From: Daun Johnson <Daun.Johnson@arun.gov.uk>
Sent: 17 February 2021 14:11
To: Planning.Responses <Planning.Responses@arun.gov.uk>
Subject: FW: LU/19/21/PDH

From: Karen Freeman [REDACTED]
Sent: 17 February 2021 14:09
To: Planning <Planning@arun.gov.uk>
Subject: LU/19/21/PDH

I have lodged an official objection to this planning application today 17.02.21 - reference OWPC33884. As I could only add text to the comments box, I want to also send you photographs with explanations to further support my objection, which I have attached. I have offered to discuss the matter with the applicant, but they are unwilling to do so.

DRWG TITLE: Proposed plans
DRWG No: 1044_201
REV: -

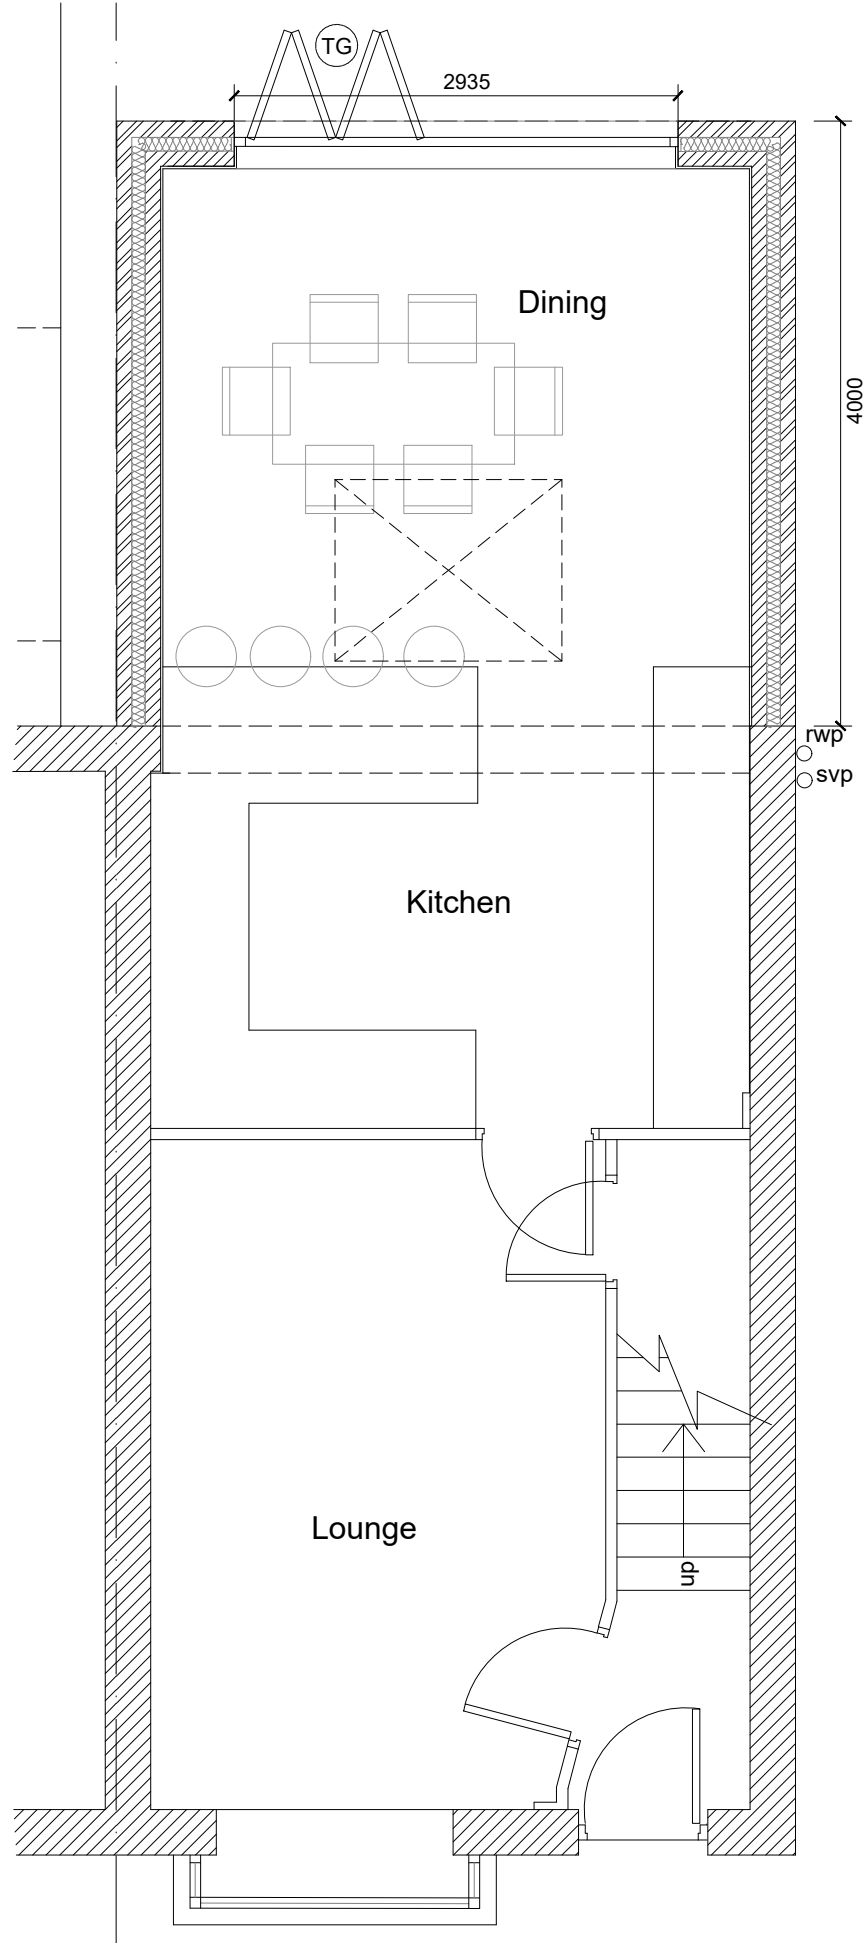
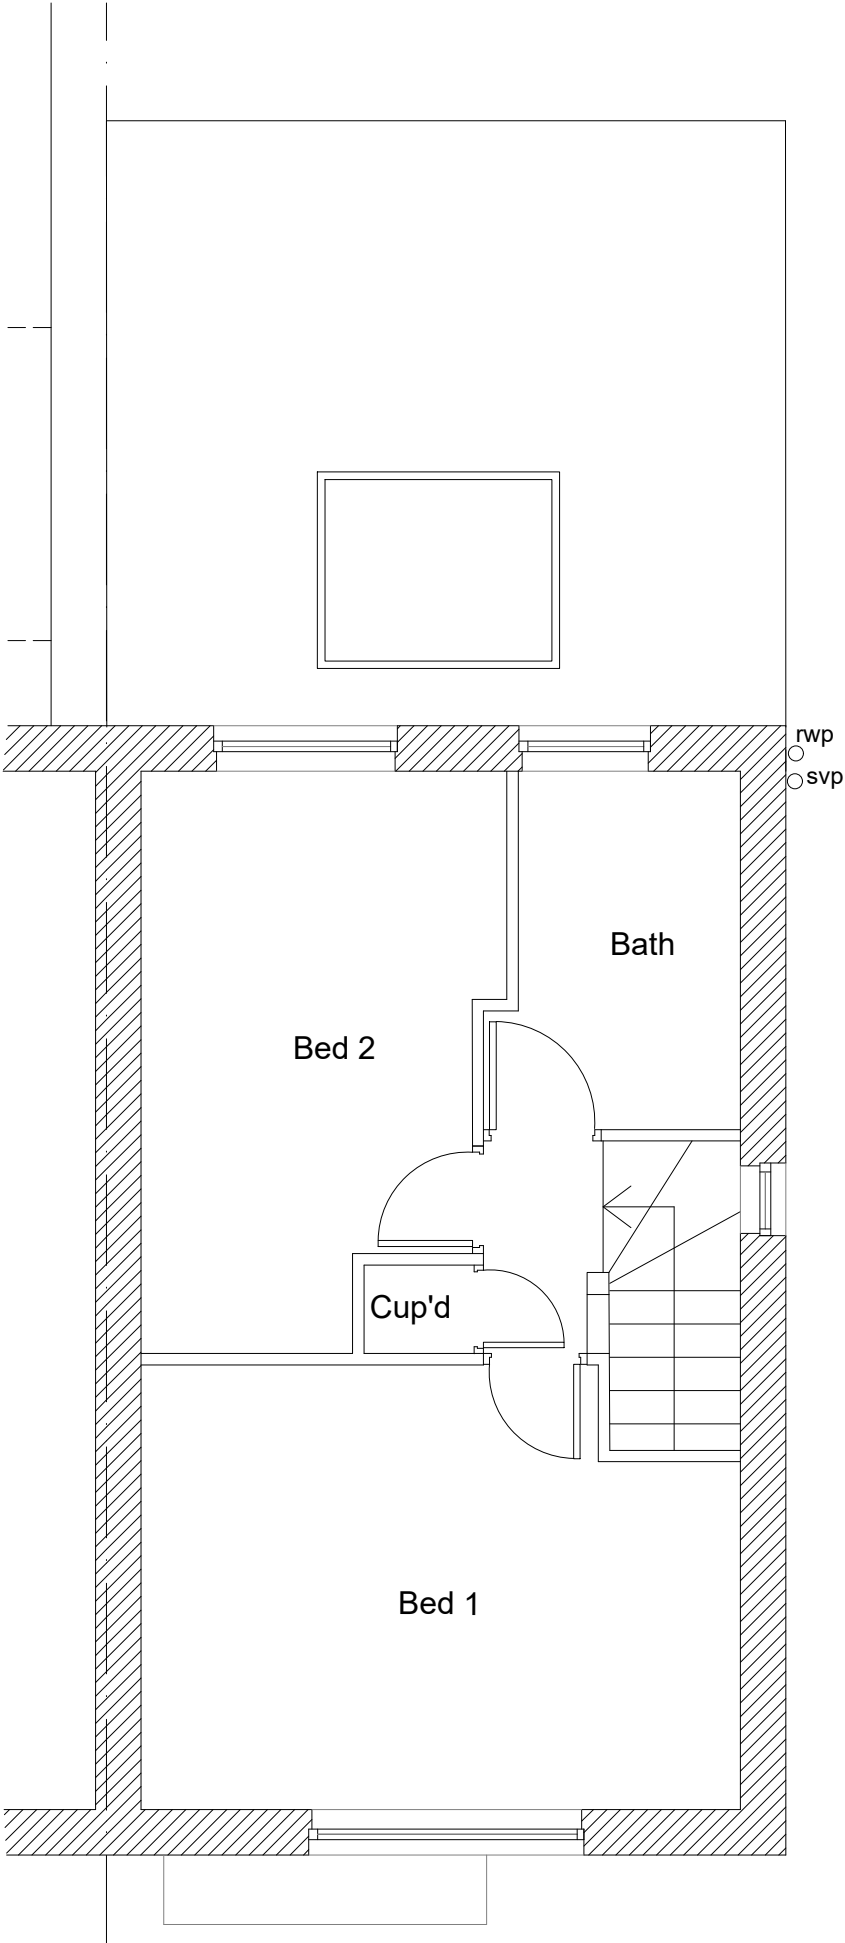
Here you can see the height and size of an existing extension next door. I am concerned that the planned extension will be as high as the neighbours and therefore as high as the conservatory, which will result in a brick wall right across my back garden, within a couple of feet of the fence.

A closer view to show the height and breadth of the proposed extension running across the back of my garden within a couple of feet of the fence.

This is the view from my lounge looking out to where the extension is proposed. My garden faces north and therefore is limited to light coming in. The conservatory that is present reflects the light as it is white and semi-transparent. If it is replaced by the brick extension, similar to the neighbours, I am concerned that there will be a reduction of light due to the height and length of the proposed extension.
